KIRKLEES COUNCIL PLANNING APPLICATION 2020/92350

LAND SOUTH OF HEYBECK LANE, CHIDSWELL, SHAW CROSS, DEWSBURY

ADVICE ON AMENDED SECTION 106 DRAFT AGREEMENT

Off Site BNG Area Plan

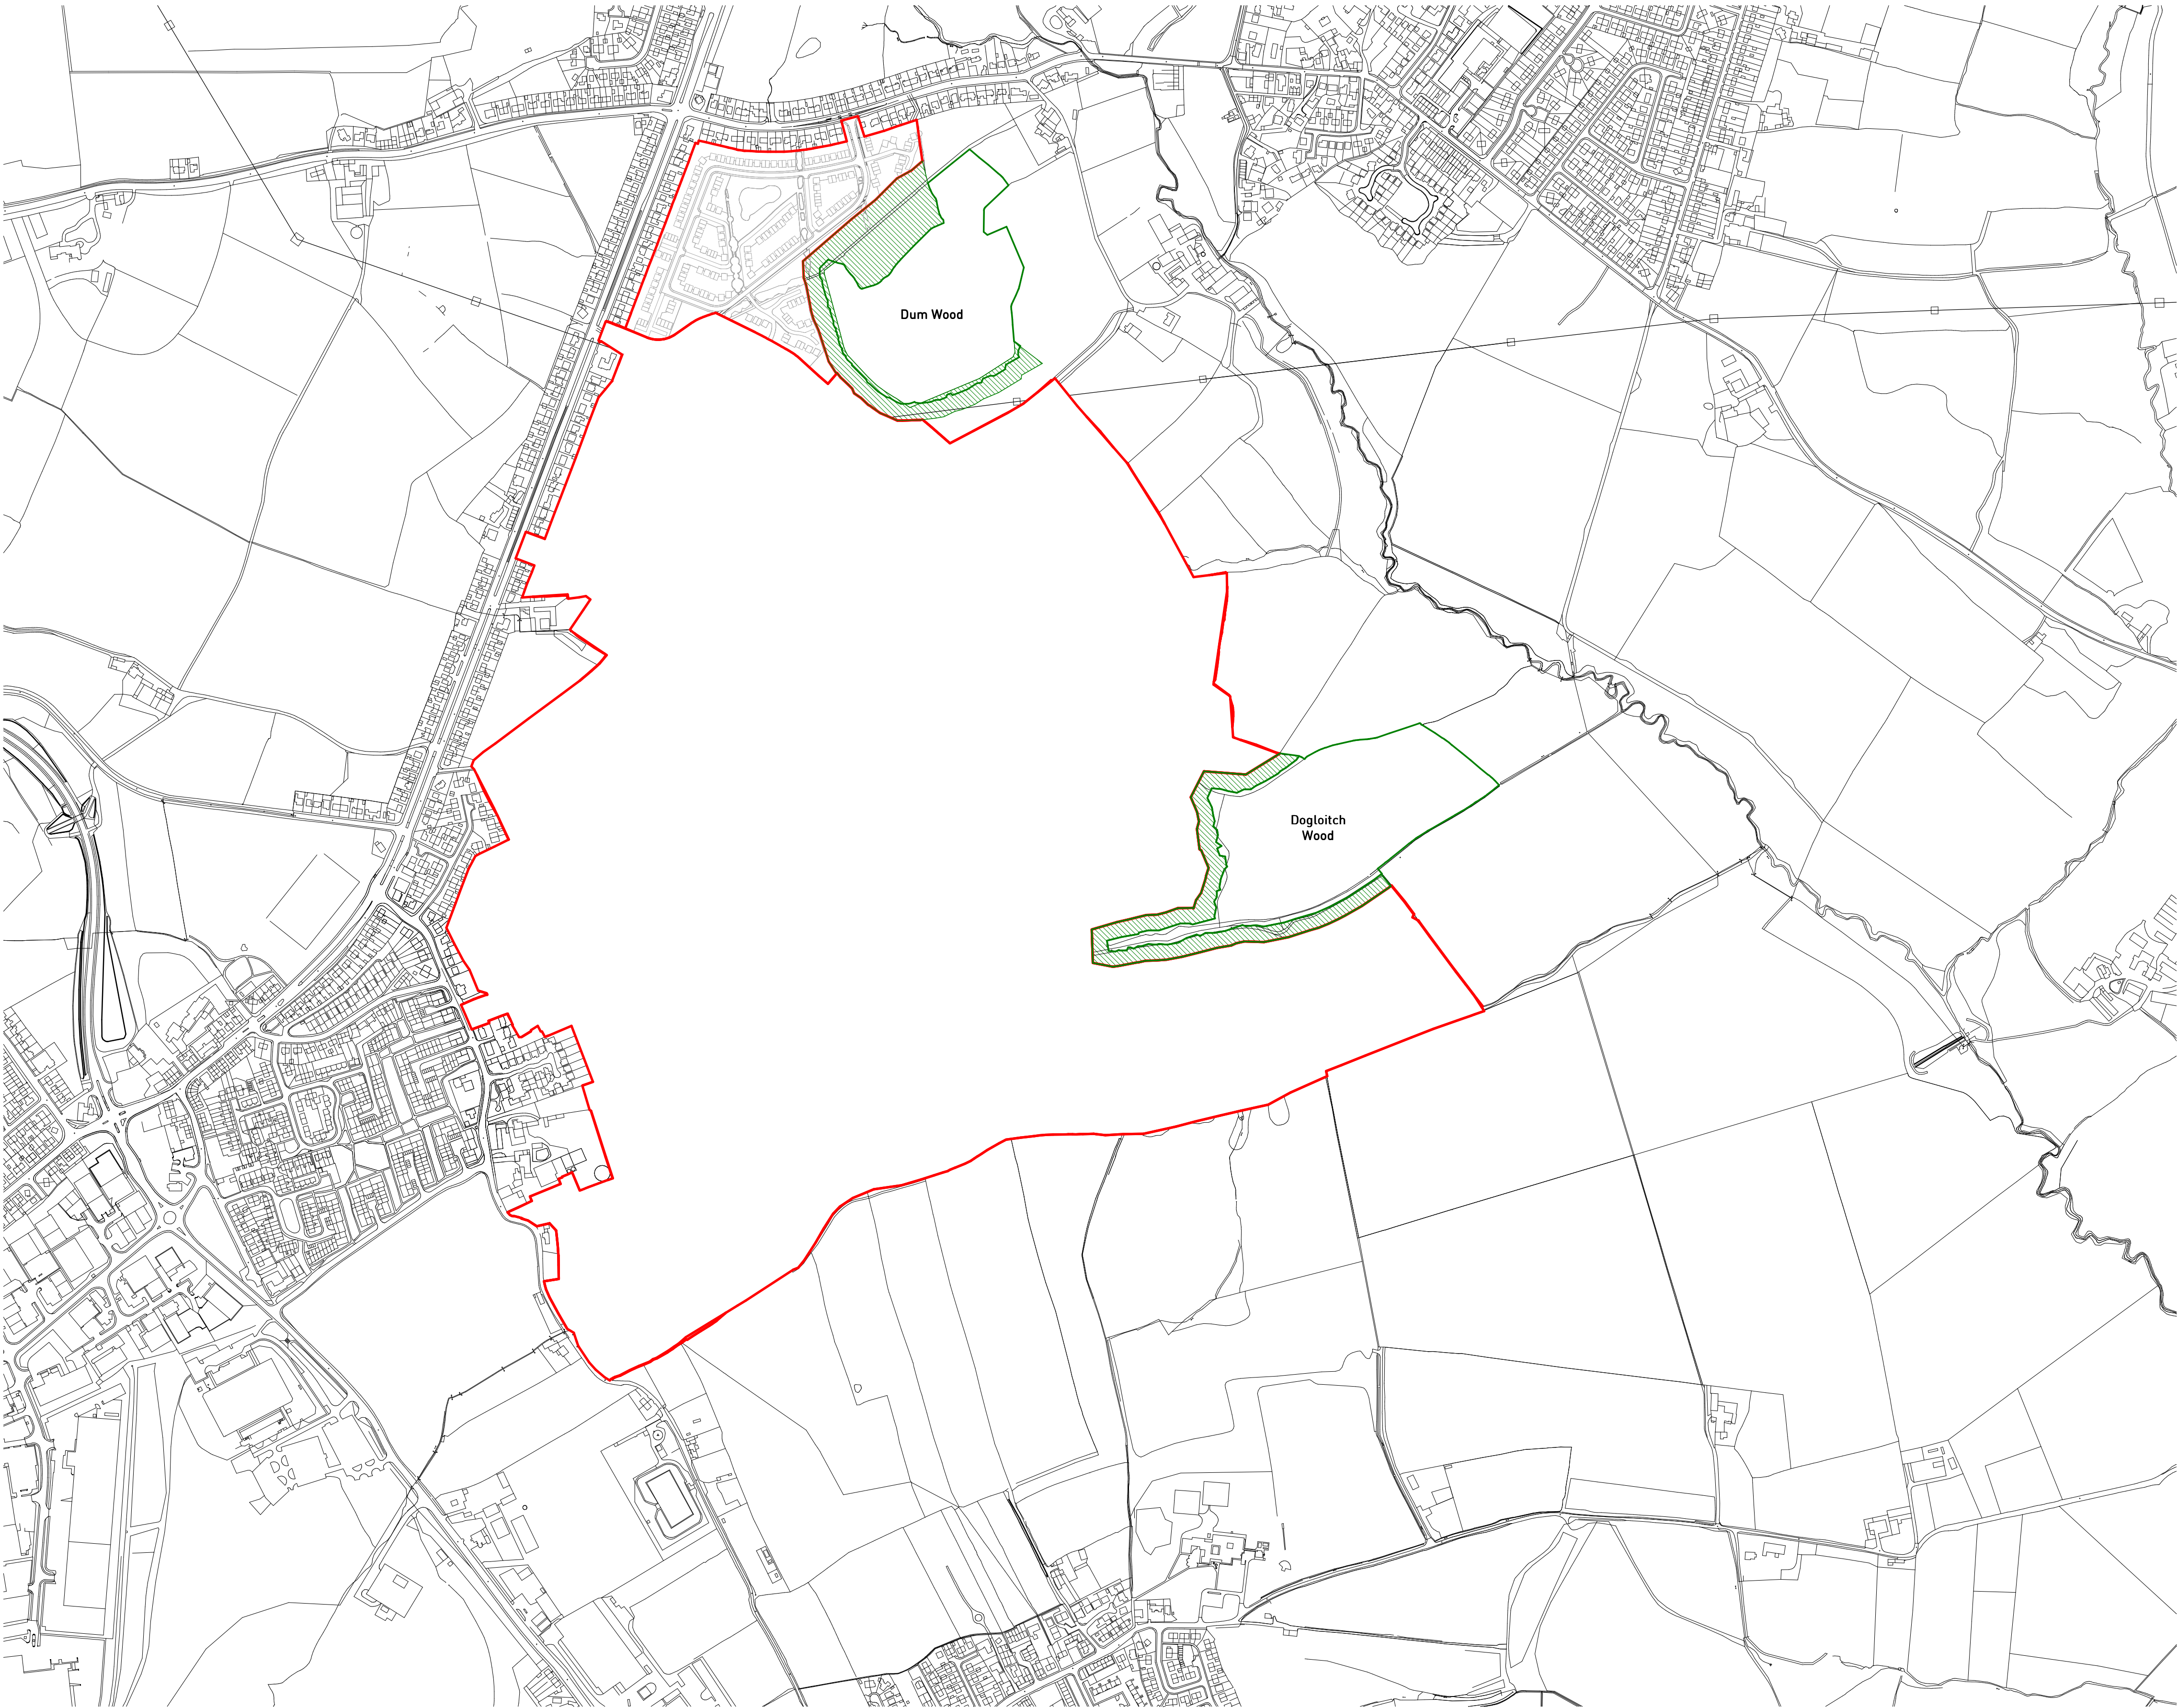
9. This latest draft changes the definition of the "*Offsite BNG land*" from "*the Ancient Woodland Land*" to "*the Ancient Woodland buffer*" (Schedule 5, p.55)
10. The effect is that whatever percentage of the required 10% BNG cannot be achieved onsite will have to be achieved within the woodland buffers to Dum Wood and Dogloitch Wood – bearing in mind that these buffers will have to accommodate the offsite BNG for the larger Leeds Road site as well (see the plan at Appendix 5 to the section 106 agreement).
11. It is surprising that this change has been proposed at such a late stage, without any evidence that what the November 6th draft requires is achievable in practice.

15. The SPC may wish to consider whether the now substantially reduced size of the land available for offsite BNG, i.e. just the woodland buffers and not the woodland itself as originally envisaged, is realistically capable of achieving the offsite BNG requirements for both developments. The statutory 10% BNG requirement does not apply to this development, but the section 106 agreement exists to make the development acceptable in planning terms: if it cannot practically achieve 10% BNG then it should not be relied on.
